Project Title: Get a Grip Building Permit #: _____ City Drainage #: _____

Re: Get a Grip
11840 Cochiti SE
Traffic Circulation Layout
Architect's Stamp 02-27-17 (L21-D058)

Based upon the information provided in your submittal received 02-28-17, the above referenced plan cannot be approved for Building Permit until the following comments are addressed:

SHEET NO:
A1.2

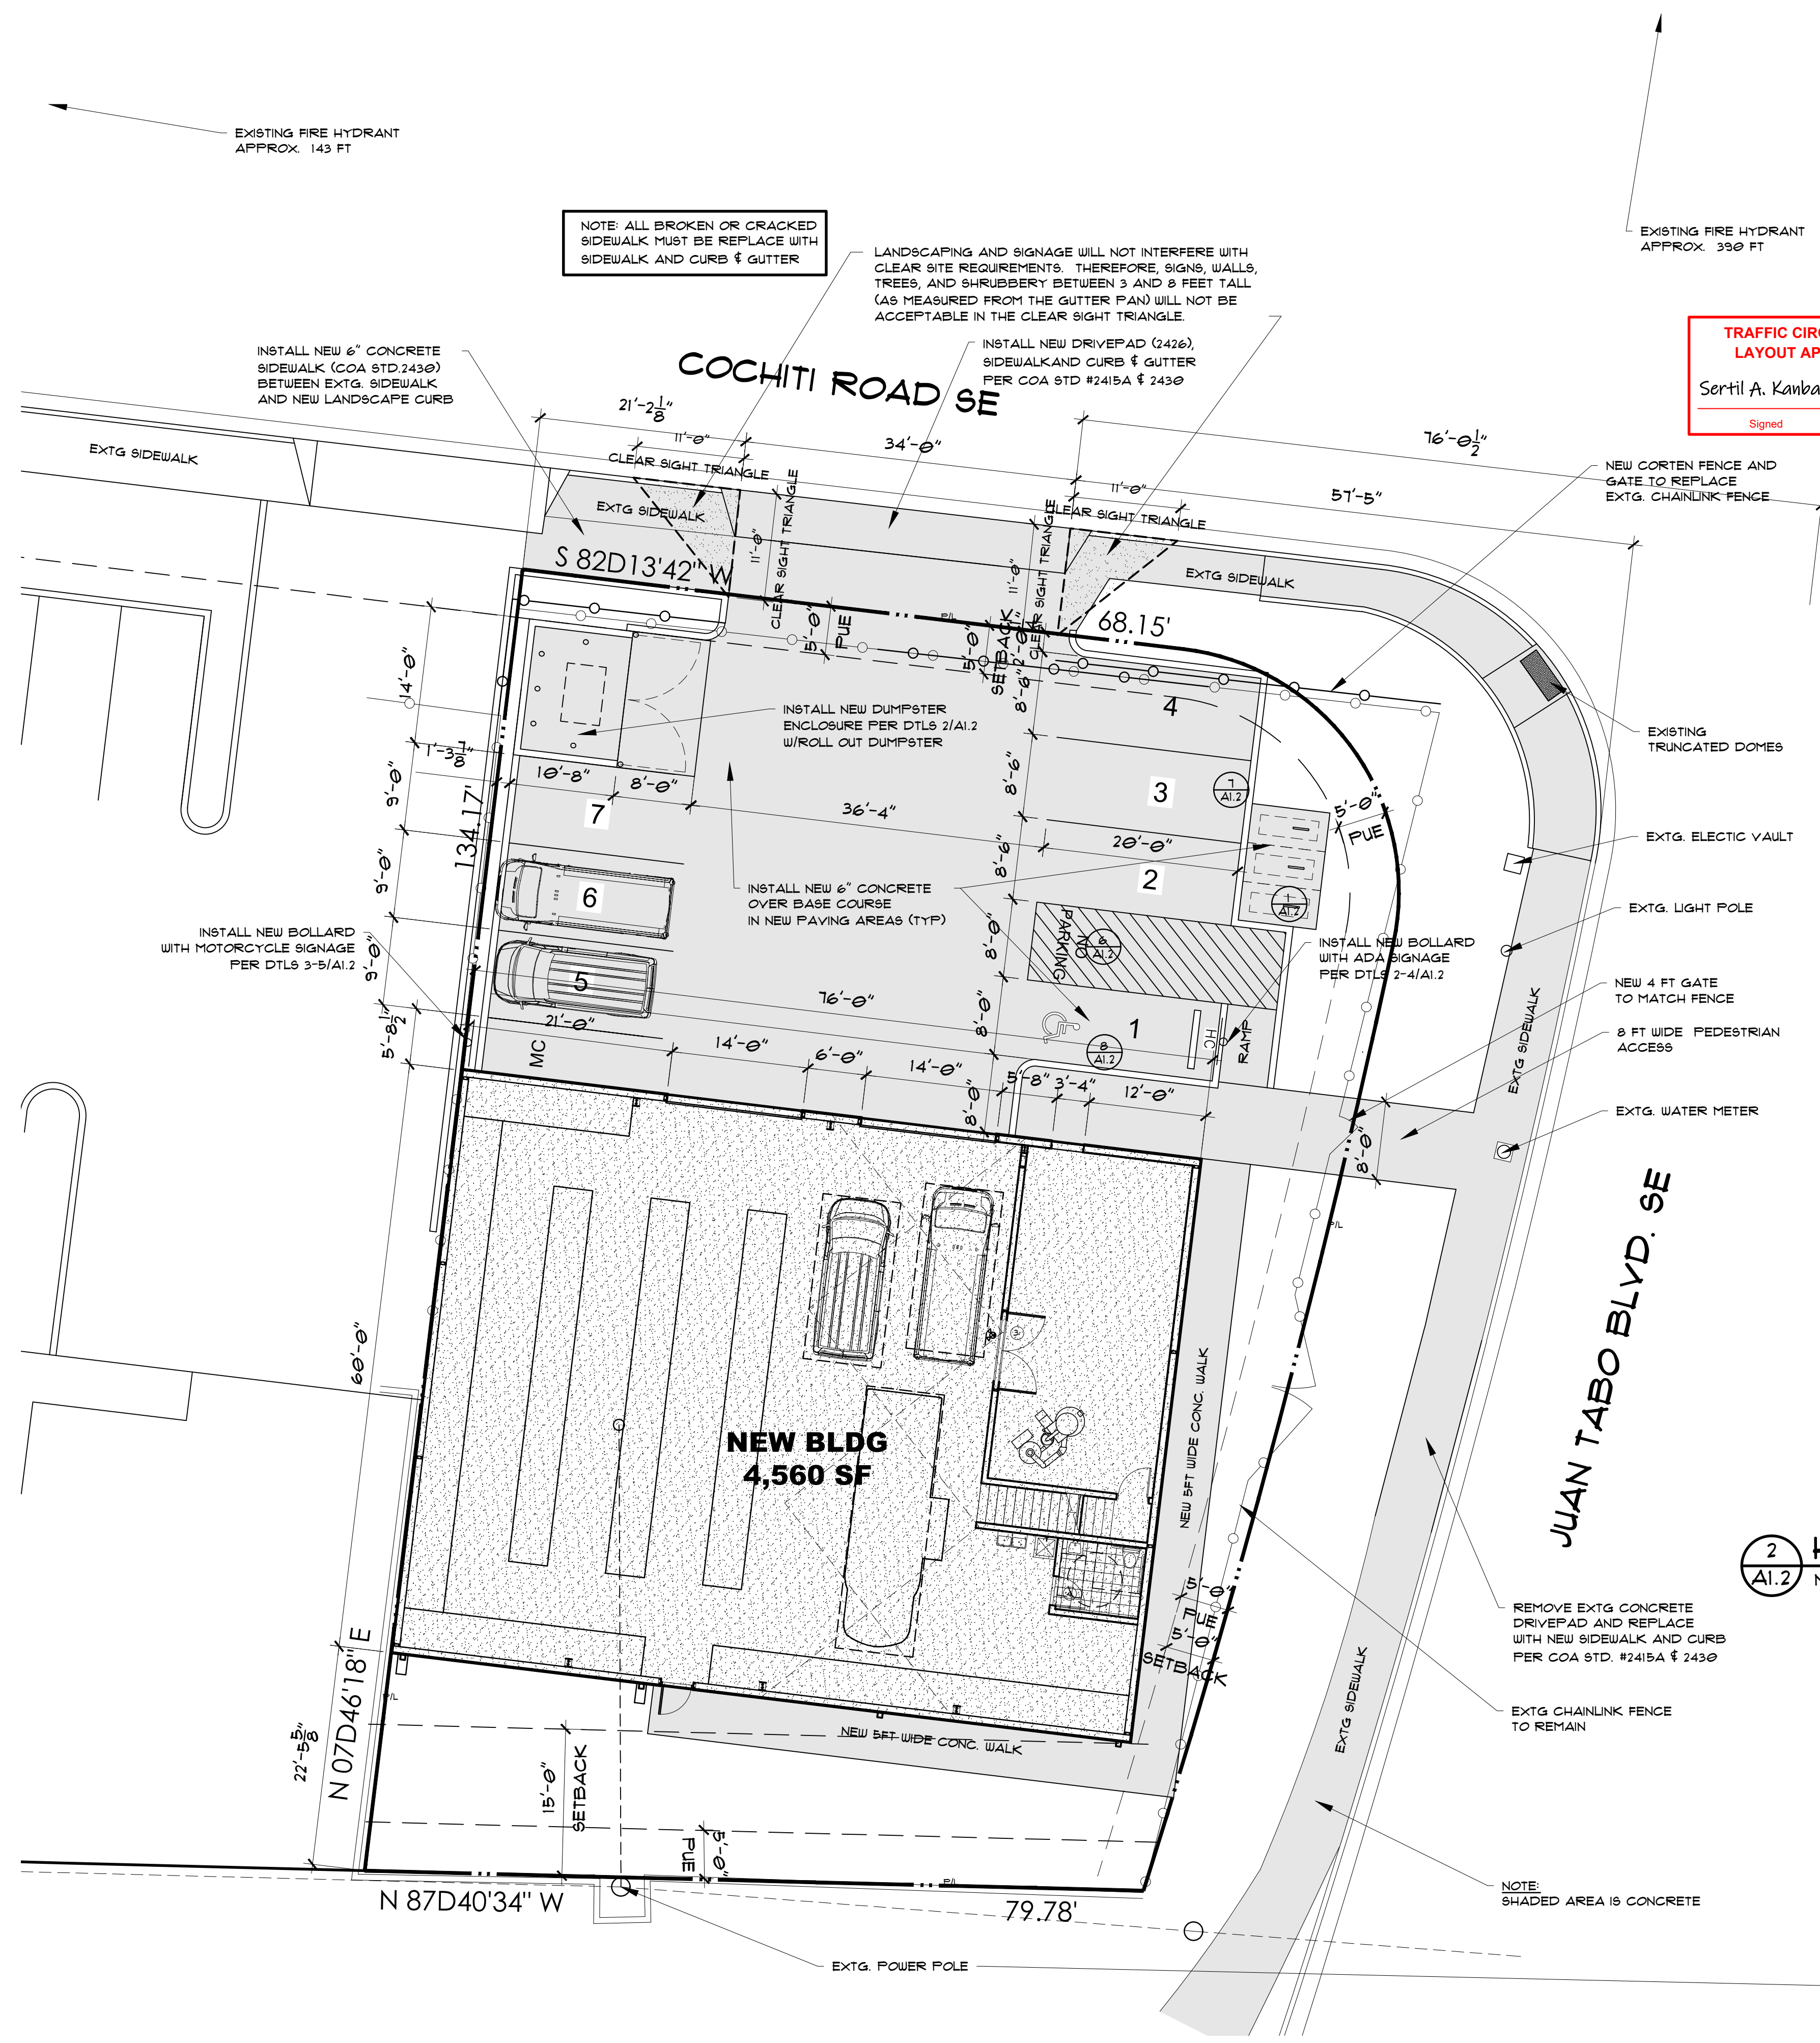
1. Per the zoning code, a 6 ft. wide ADA accessible pedestrian pathway is required from the public sidewalk to the building entrances. Please clearly show this pathway and provide details.
2. Please show detail for the pedestrian path on the west side of lot. This should be ADA accessible.
3. Please specify the City Standard Drawing Number when applicable.
4. Please show dimension of existing shared driveway.
5. Please include a copy of your shared access agreement with the adjacent property owner.
6. Please include two copies of the traffic circulation layout at the next submittal.
